**From:**  
**Sent:** 10 July 2025 12:58  
**To:** DC Admin  
**Subject:** Objection for planning at 62 Burfitts Road HD34YL

2025/62/91157/W

62 Burfitts road

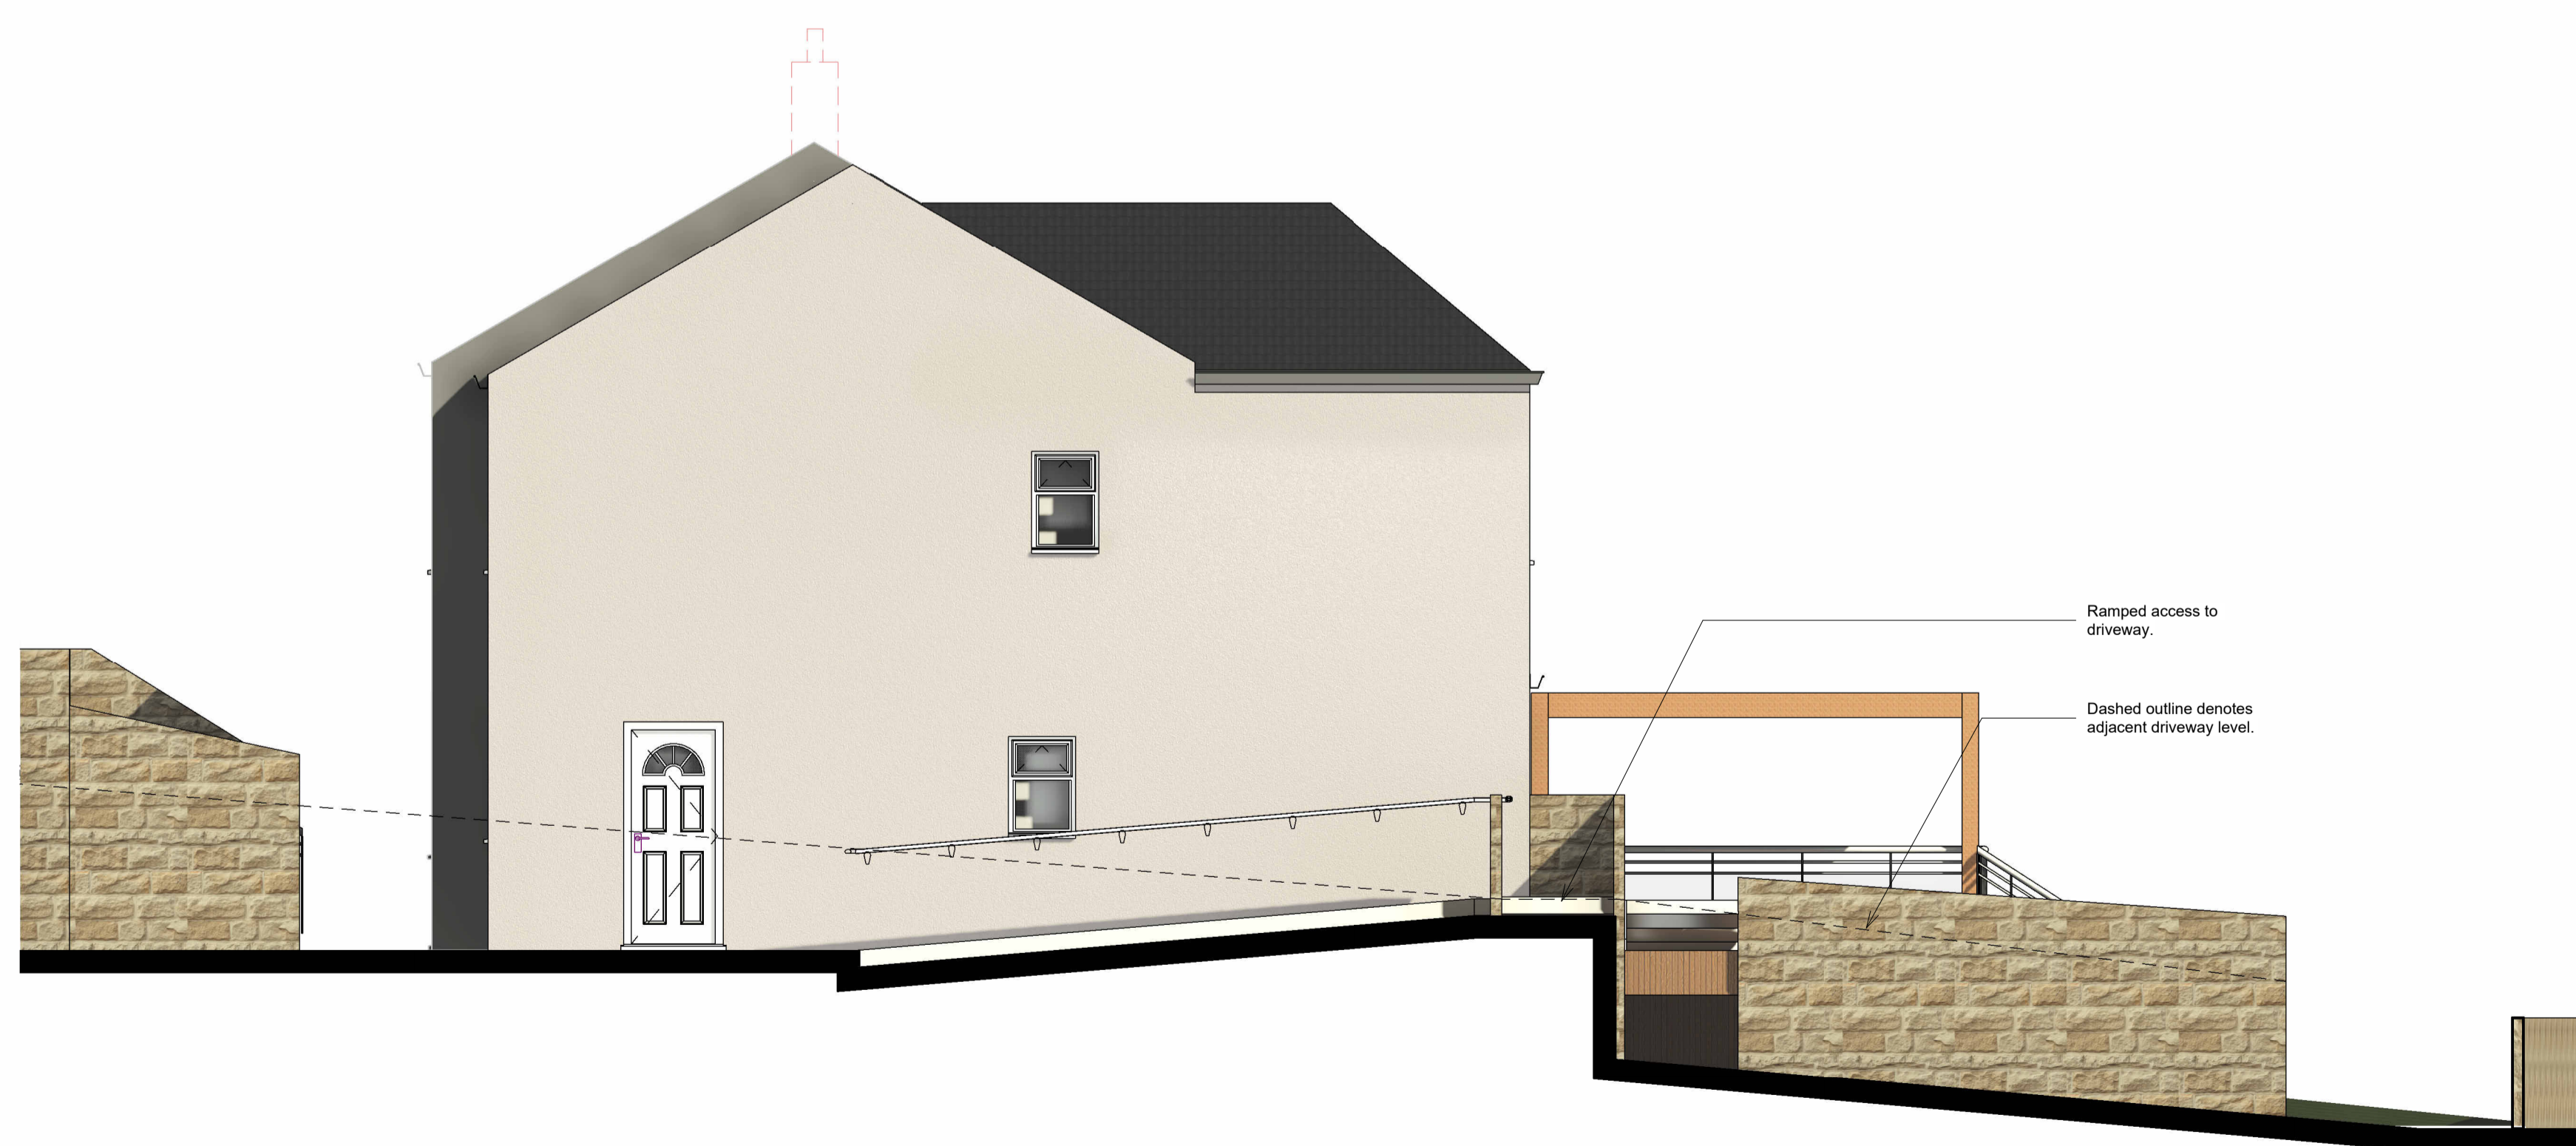
The proposed two-storey extension around the side and rear of 62 will directly overshadow my property (number 64). The building will cast a shadow over my property this means I will lose vital daylight on the only side of my home that receives natural sunlight. I have lived here for over 20 years and have always benefited from sunlight coming in through this side of the property. This change will make my bedroom feel dark, enclosed, and oppressive.

The planned raised terrace and pergola, attached to the new extension at the rear, will further infringe on my privacy. The height of this structure will allow residents at 62 to overlook my garden, removing any sense of seclusion. Combined with the proposed two-storey build, this would create a completely unacceptable intrusion into my private space.

There are no other two-storey extensions on Burfitts Road for good reason – they block sunlight and overlook neighbouring properties. It is entirely inappropriate to convert a modest two-bedroom home into a five-bedroom house in an already tightly spaced council estate. The scale of the proposed development is excessive and out of character with the rest of the street.

Description
PROPOSED DRIVEWAY PLANS AND ELEVATIONS

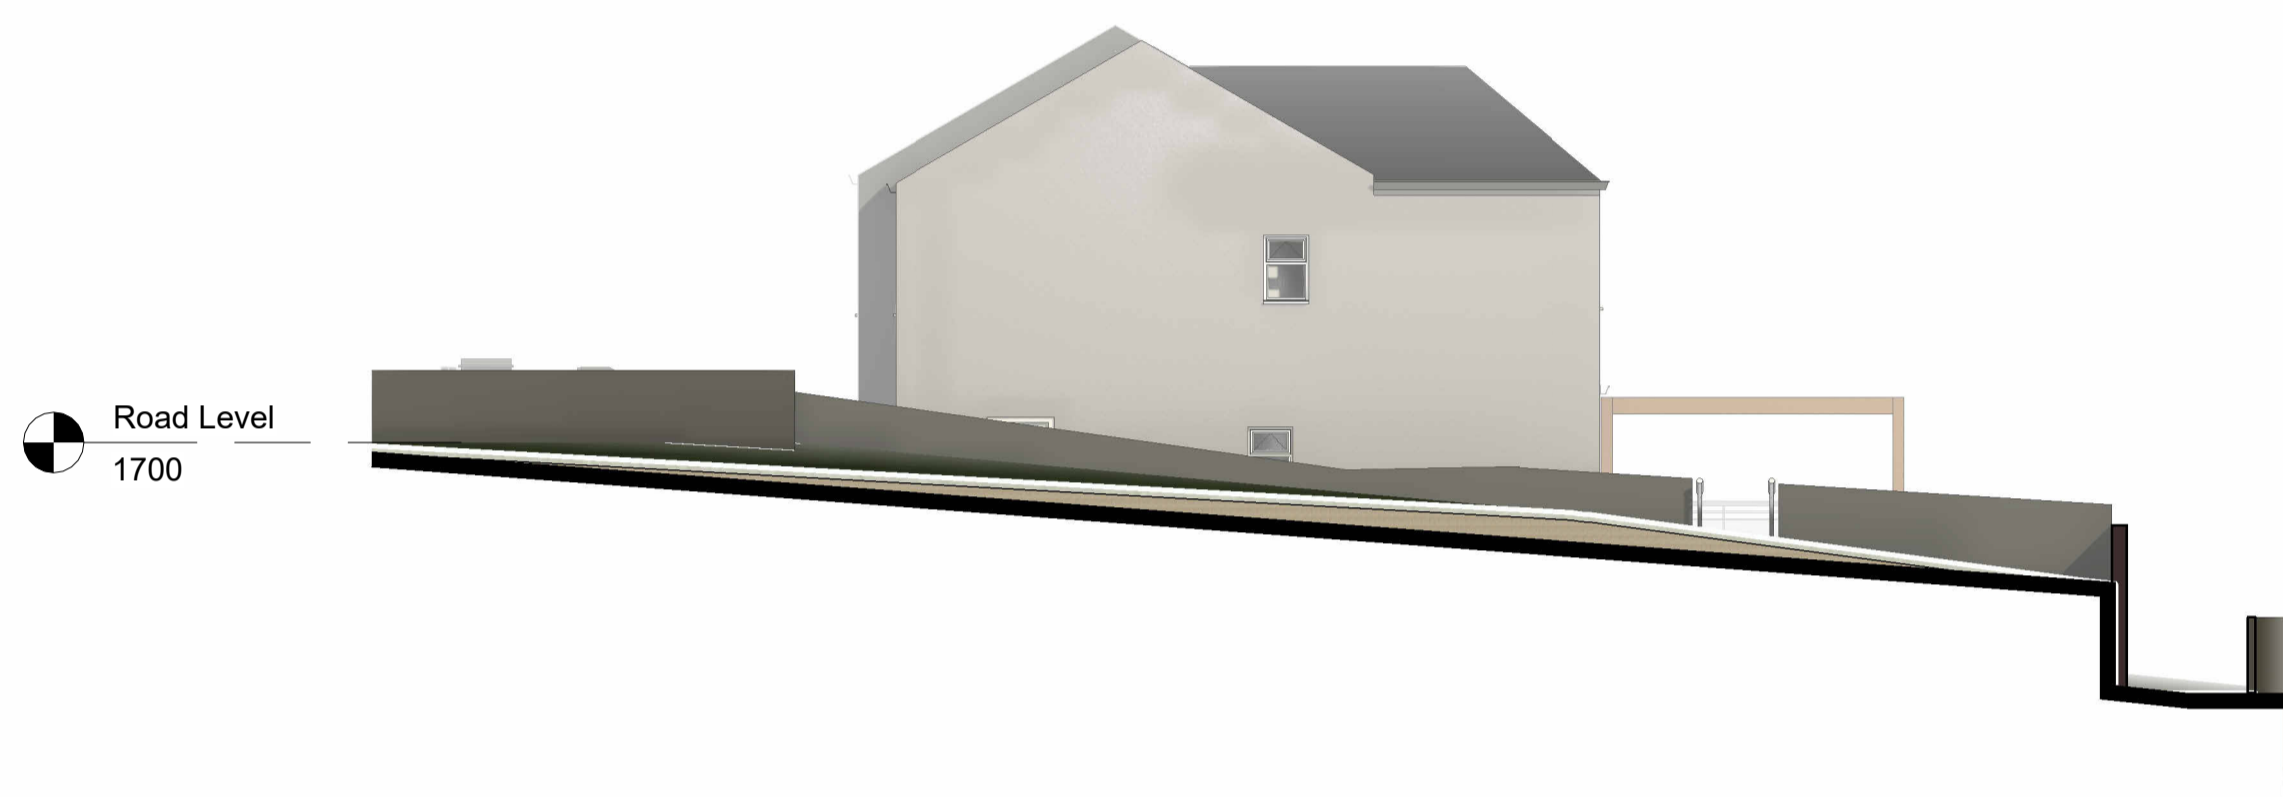
The field beside 62 is council-owned and has long been used by residents for dog walking, recreation, and children's play. The applicant now seeks to convert part of this into a driveway for two cars. This is deeply unfair, especially as local residents, including myself, were never informed that this land might be available for sale. Had we been made aware, many of us would have been interested in securing a small piece for our own parking needs. The replacement of green space with concrete will negatively impact the street's visual appeal.

Furthermore, any new driveway using the council field would require removal or relocation of a public lamp post.
